**WELWYN HATFIELD COUNCIL – DEVELOPMENT CONTROL**  
**DELEGATED REPORT**

<b>APPLICATION No:</b>	<b>S6/2011/0198/FP</b>
------------------------	------------------------

The proposal is to convert the existing residential unit on the ground floor of the detached outbuilding to be used as a garden room.

EXISTING

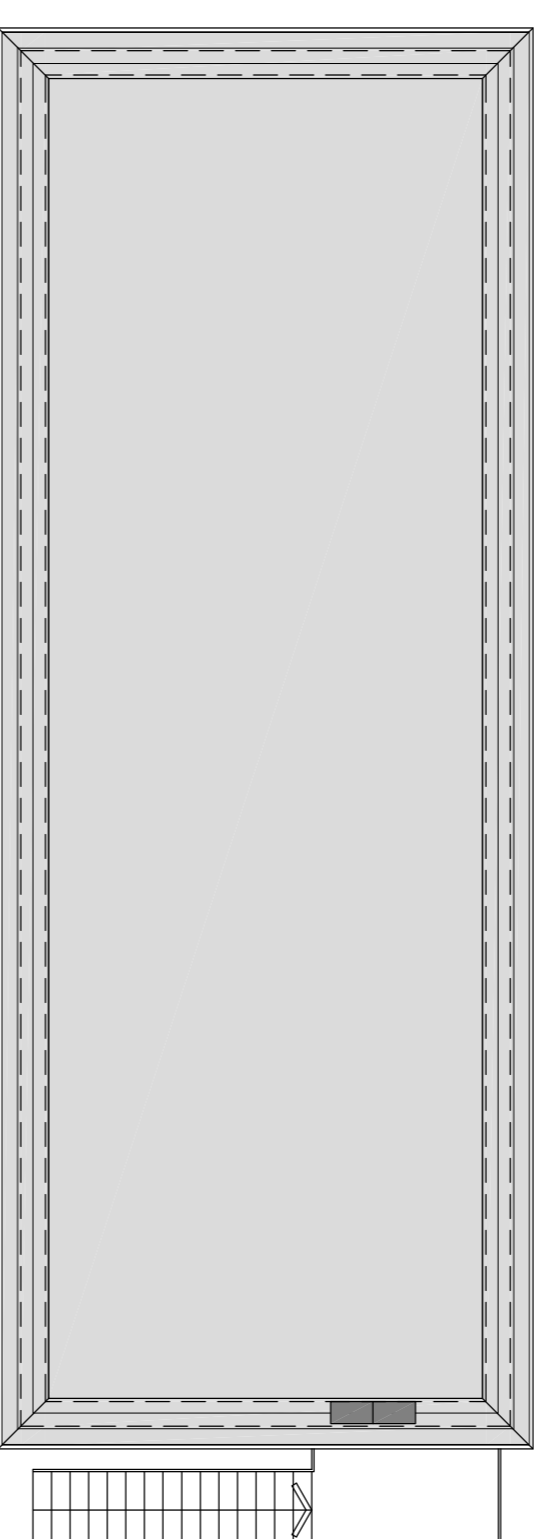
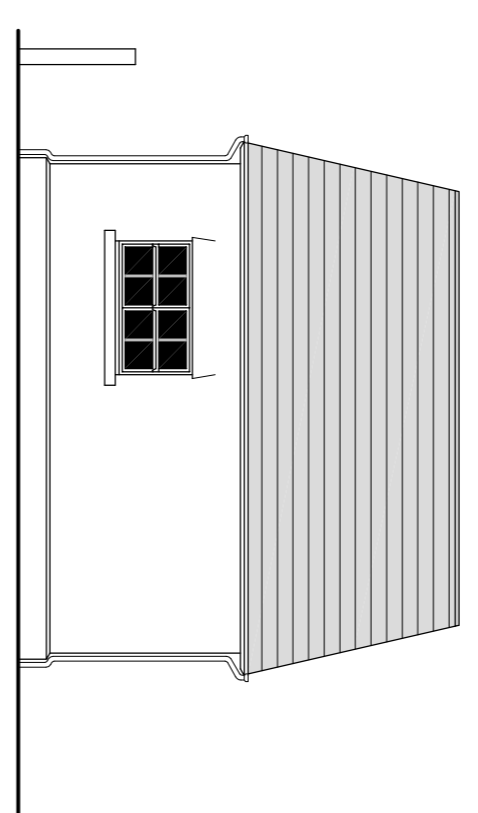
Since the implementation of these two permissions, the applicant has converted the original storage area in the roofspace to a two bedroom staff annexe. A further six rooflights have been added to the roofspace to create five rooflights on both the front and rear elevations. External steps have also been added to the southern elevation of the outbuilding which creates the only access to the habitable accommodation above.

With regards to visual impact, the additional rooflights and external staircase are not considered to be of a size to cause an adverse visual impact taking into consideration that the alterations are minimal.

The dwellinghouse and outbuilding is located on a large plot within a rural setting. The general characteristics of properties within the vicinity of Kentish Lane are generally large detached dwellings located within large residential plots. The addition of the rooflights and external staircase are not considered to impact on the overall character of the surrounding area taking into consideration that rooflights exist already exist on the outbuilding and it is largely screened from the highway and surrounding area by mature landscaping along the boundary and therefore any impact on the surrounding area is limited. The proposed is considered to comply with policy D1 and D2 of the Welwyn Hatfield District Plan, 2005.

ground floor plan - as built

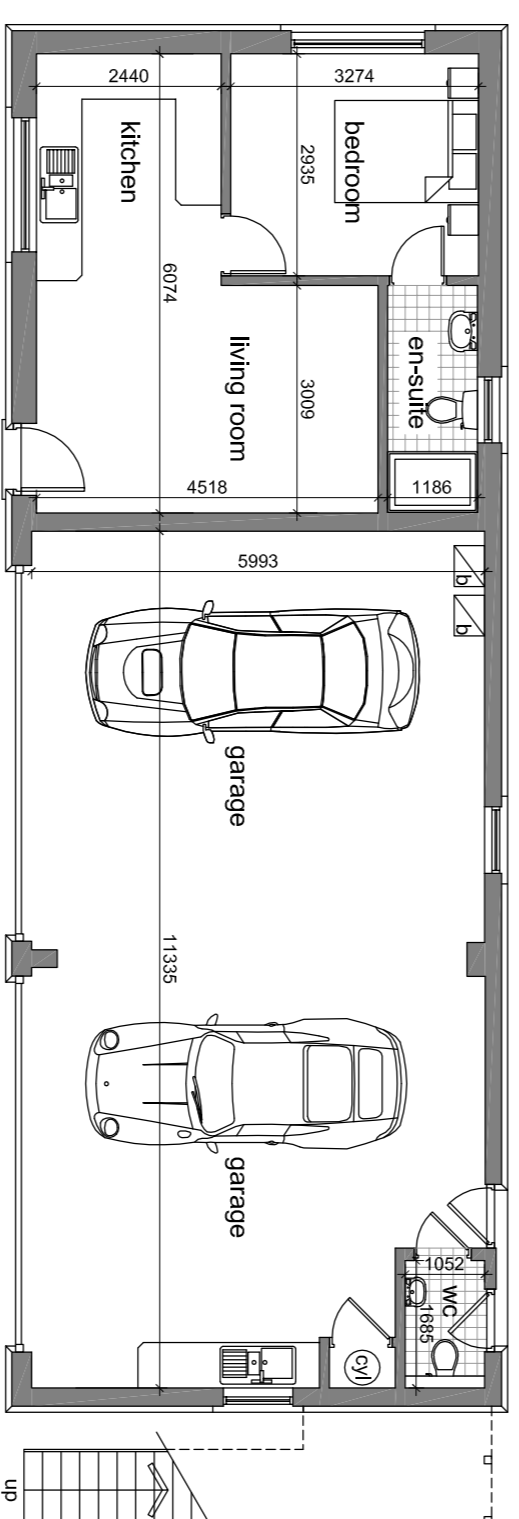
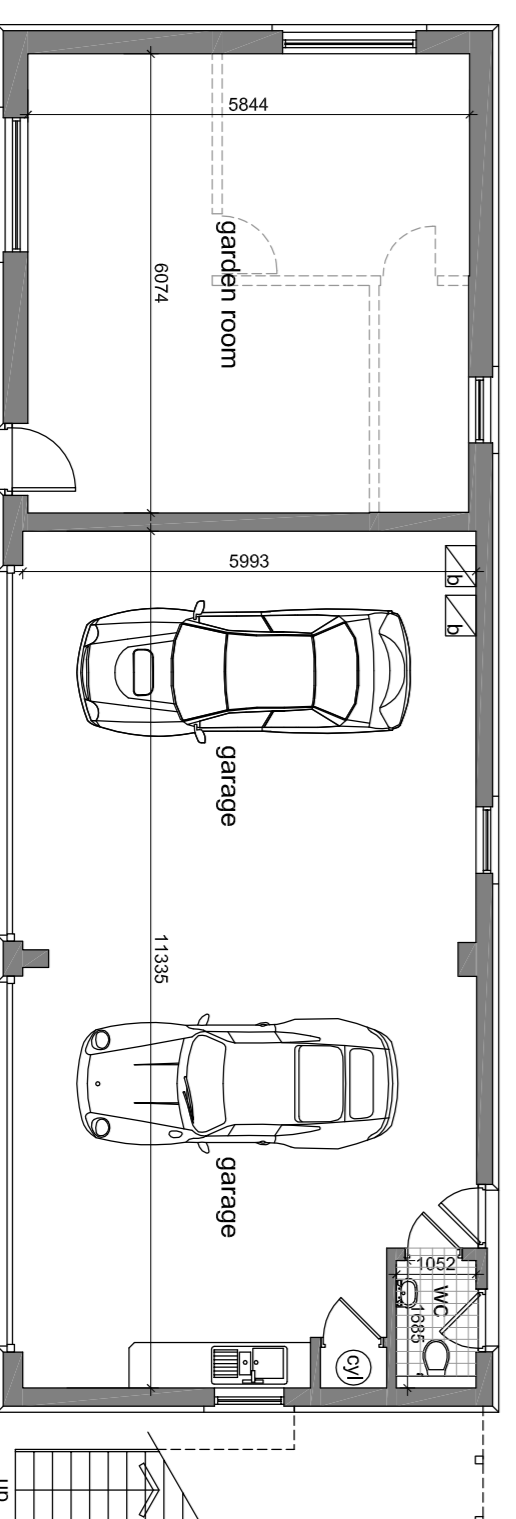
As part of this application, the applicant seeks the retention of the two bedroom, first floor annexe and convert the existing one bedroom, ground floor annexe into a garden room. The application also seeks the retention of the external alterations including the addition rooflights and external staircase and these alterations form the discussion below.

3. The permission hereby approved shall cease being occupied as a residential annexe on the ground floor as shown on drawing no. 10424/S/001 within three months of the date of this permission. Thereafter, the ground floor shall be used only for purposes incidental to the use of the main dwellinghouse 'Wildewood'.

first floor plan - as built

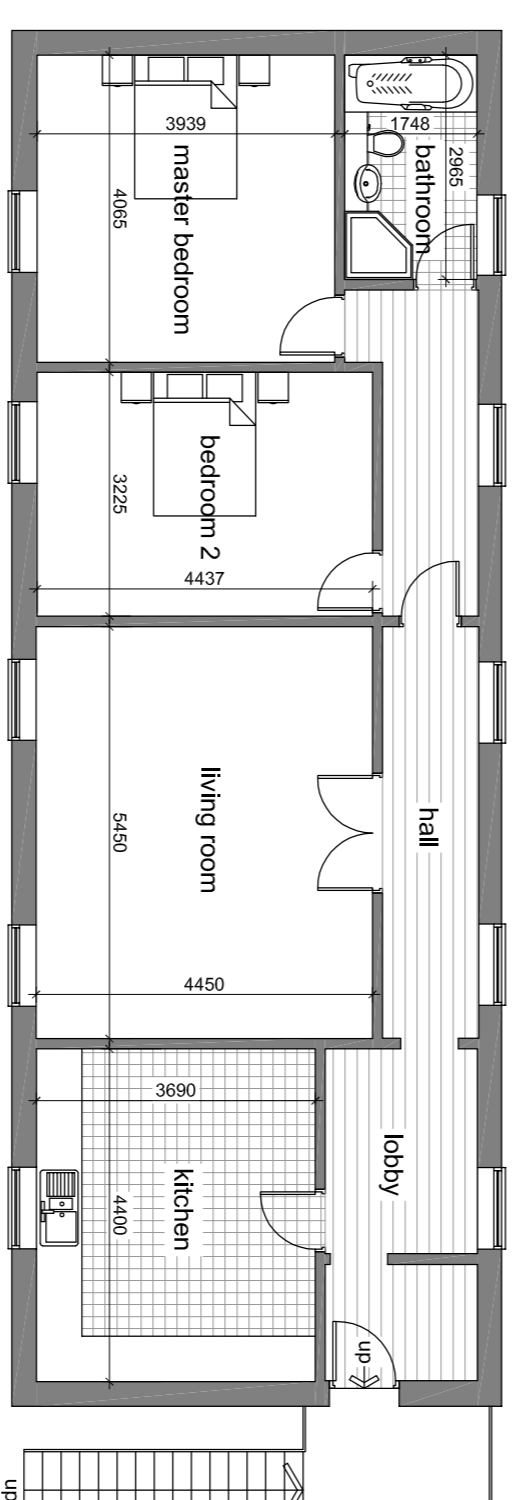
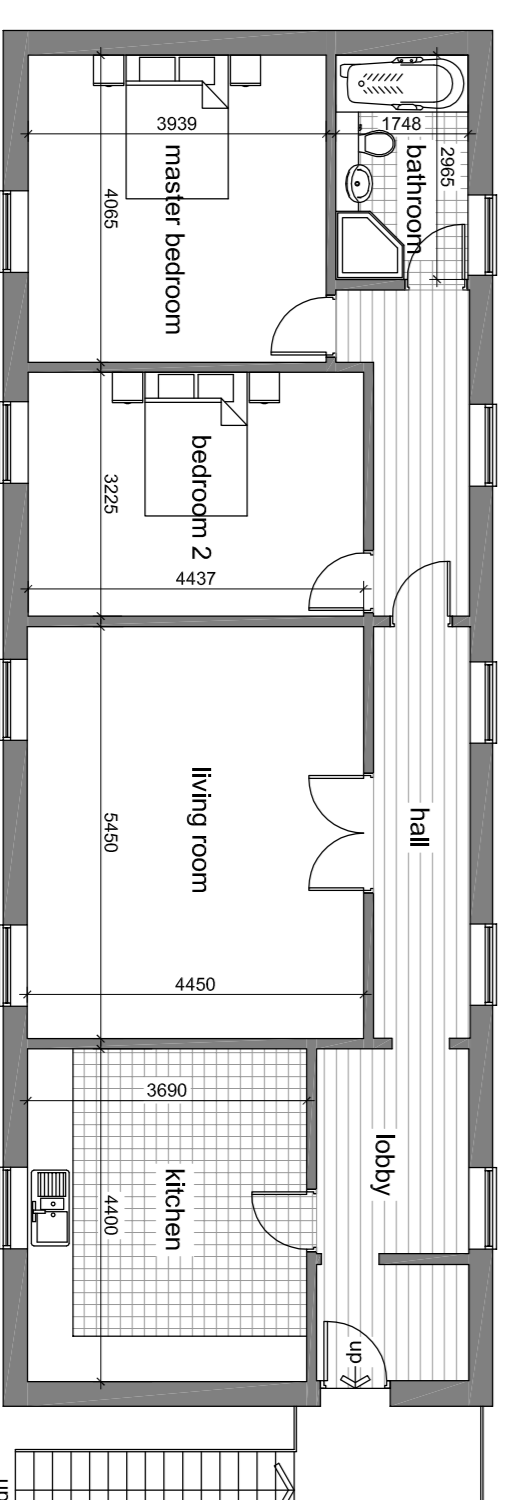
**Car Parking:** The application seeks retention of the first floor annexe which has created a further bedroom to become a two bedroom annexe in replacement of the existing one bedroom ground floor annexe which is to be converted into a garden room. Whilst the annexe is associated with the main dwellinghouse, the parking standards for a 2 bedroom dwelling are still applicable. The main dwellinghouse benefits from a large gravelled courtyard to the front and adjacent to the outbuilding which provides ample car parking for a number of cars. The retention of the two bedroom annexe is therefore not considered to impact on the car parking provision and complies with policy M14 of the Welwyn Hatfield District Plan, 2005.
